STATE OF NORTH CAROLINA
DEPARTMENT OF TRANSPORTATION

March 26, 2009

Subject: **Revised Design** for the replacement of Bridge #14 over the Cashie River on US 17 in Bertie County, in Windsor. State Project No. 8.1010801. Federal Aid Project Number BRNHS-17(35). WBS 33700.1.1. TIP No. B-4434.

The purpose of this letter is to provide plans and information for utility and hydraulic revisions. These revisions will not result in a change to the proposed impacts. Please see the attached plans for the changes described below.

PROJECT REFERENCE NO.	B-4434
SHEET NO.	UC-2
DESIGNED BY:	WOOTEN
DRAWN BY:	WOOTEN
CHECKED BY:	EWH
APPROVED BY:	COB
REVISED:	
NORTH CAROLINA DEPARTMENT OF TRANSPORTATION	
UTILITIES ENGINEERING SECTION	
PHONE: (919) 250-4128	
FAX: (919) 250-4119	
UTILITY CONSTRUCTION PLANS ONLY

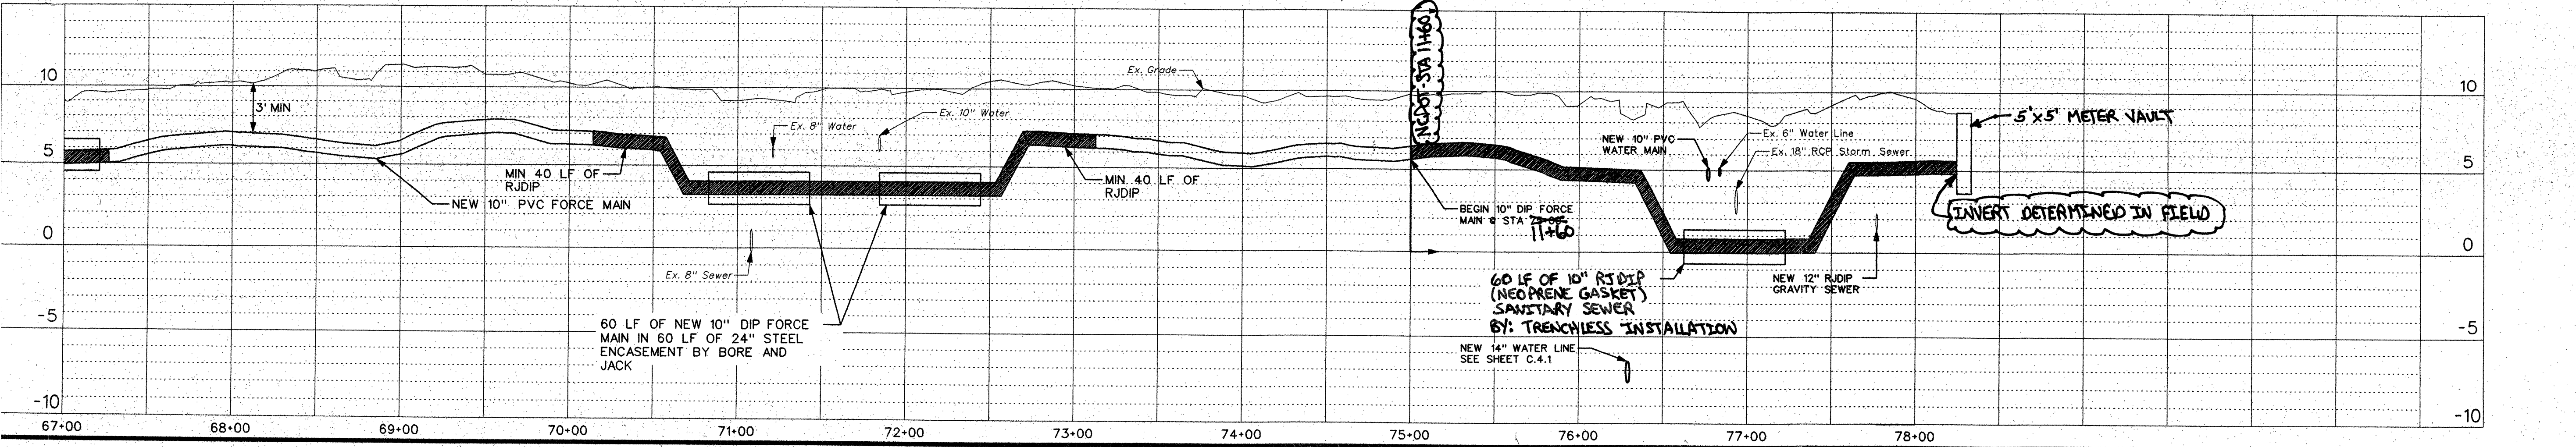
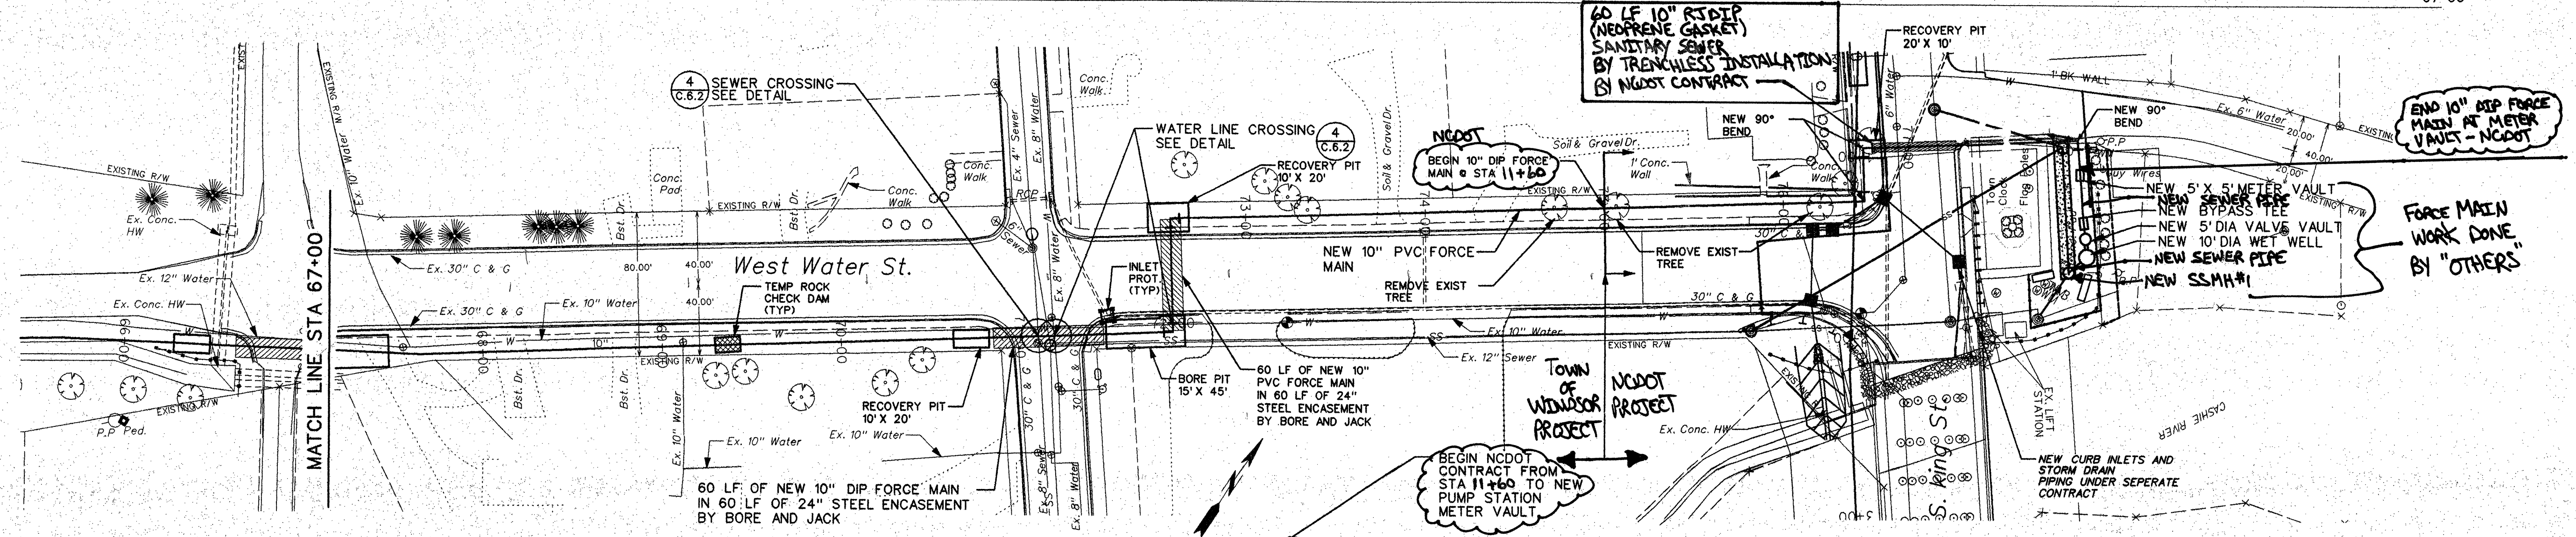
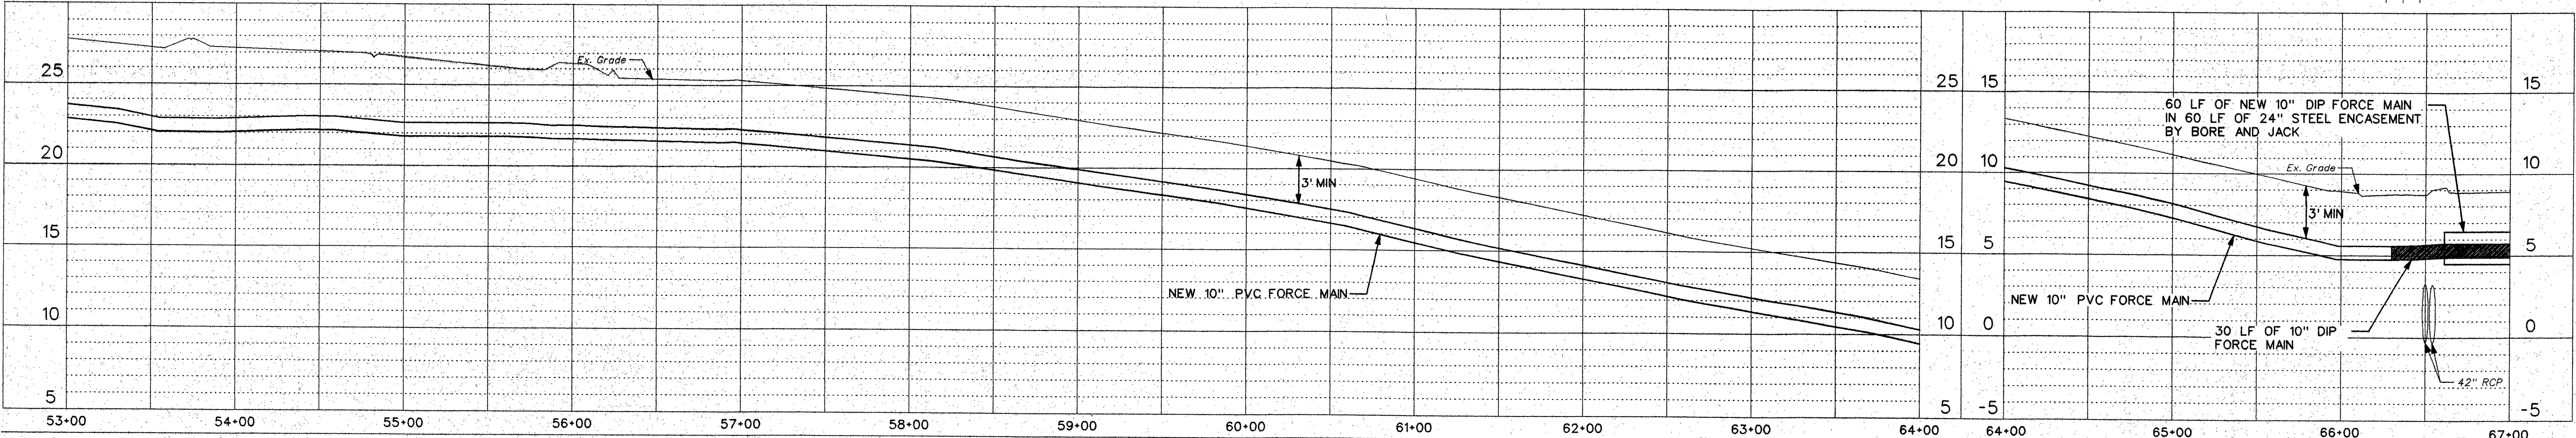
Existing 8" sanitary sewer line attached to bridge (along north east side) crossing over Cashie River will be removed. A new 10" sewer line installed along US-17 Bypass (West Water Street) will transmit sewage to Town's treatment plant without crossing Cashie River.

UTILITIES BY OTHERS

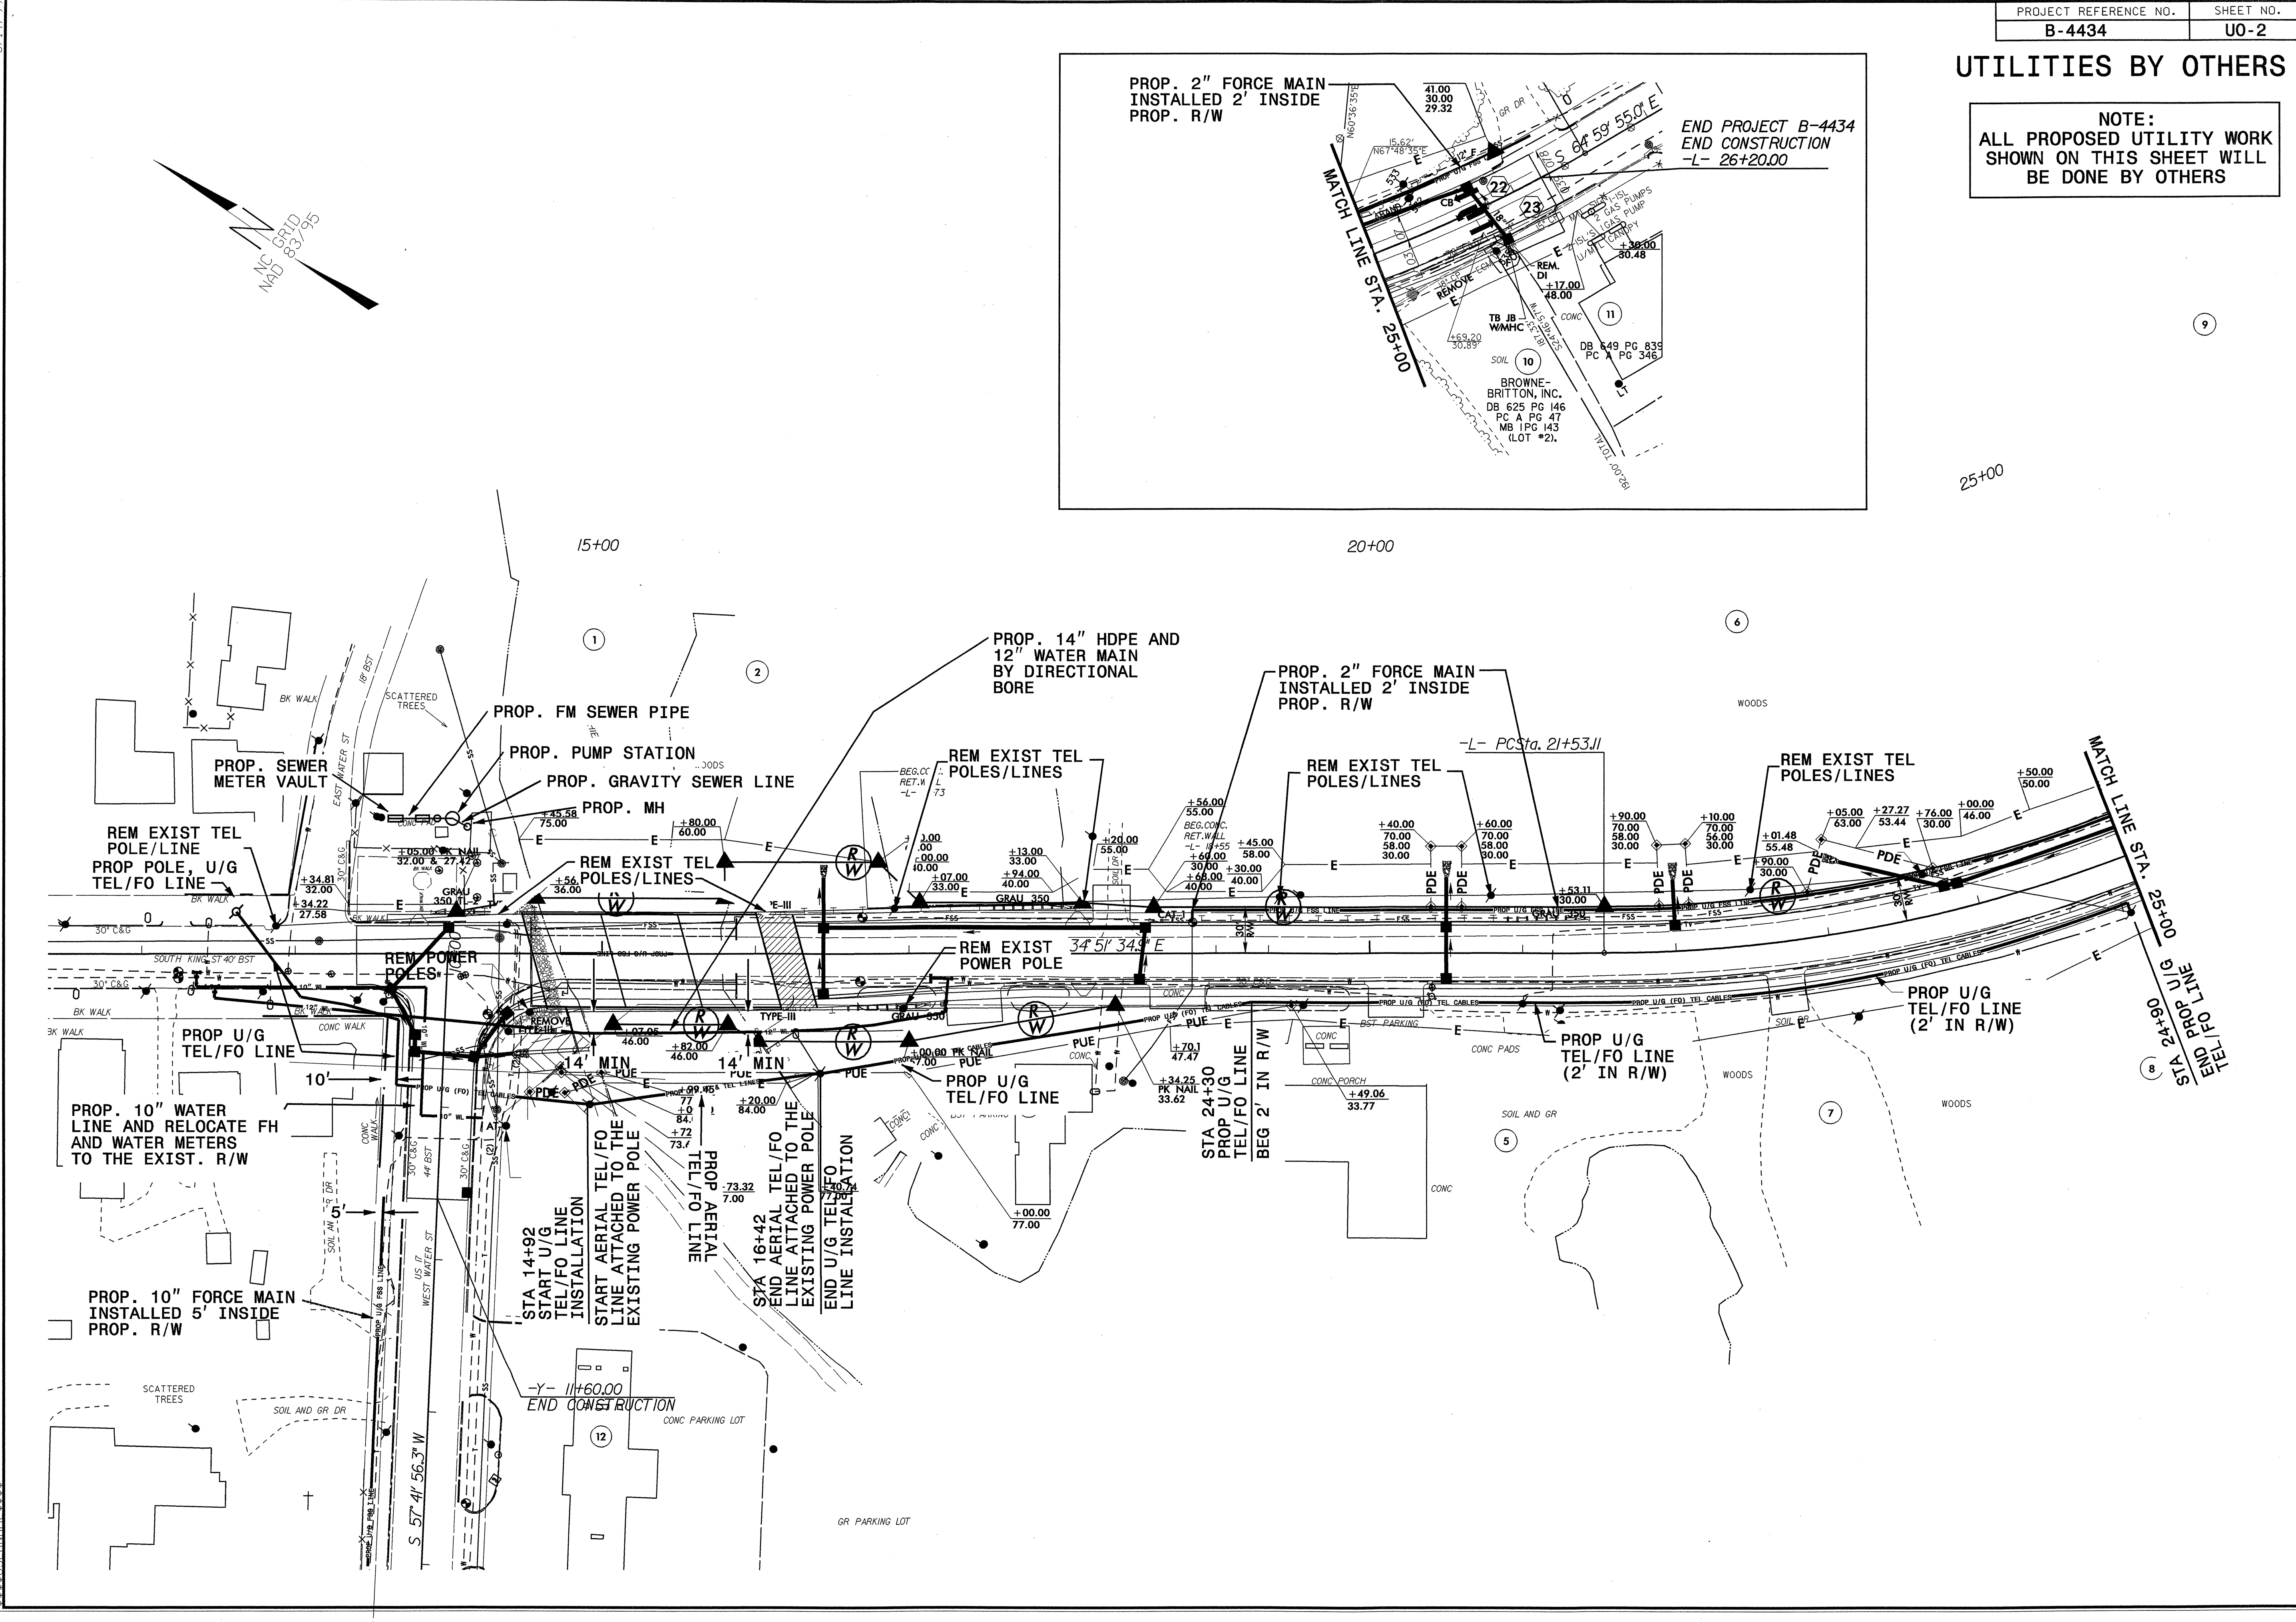
Existing overhead telephone/communication lines and poles located adjacent to bridge (northeast side) and along NC-308 (northeast side) throughout project limits will be removed.

Proposed telephone/communication lines will be relocated underground (installed by open trench) along southwest side of NC-308 (inside existing ROW) throughout project limits except under Cashie River (60' southwest of bridge) where a directional bore will be used to install underground cable (inside proposed PUE).
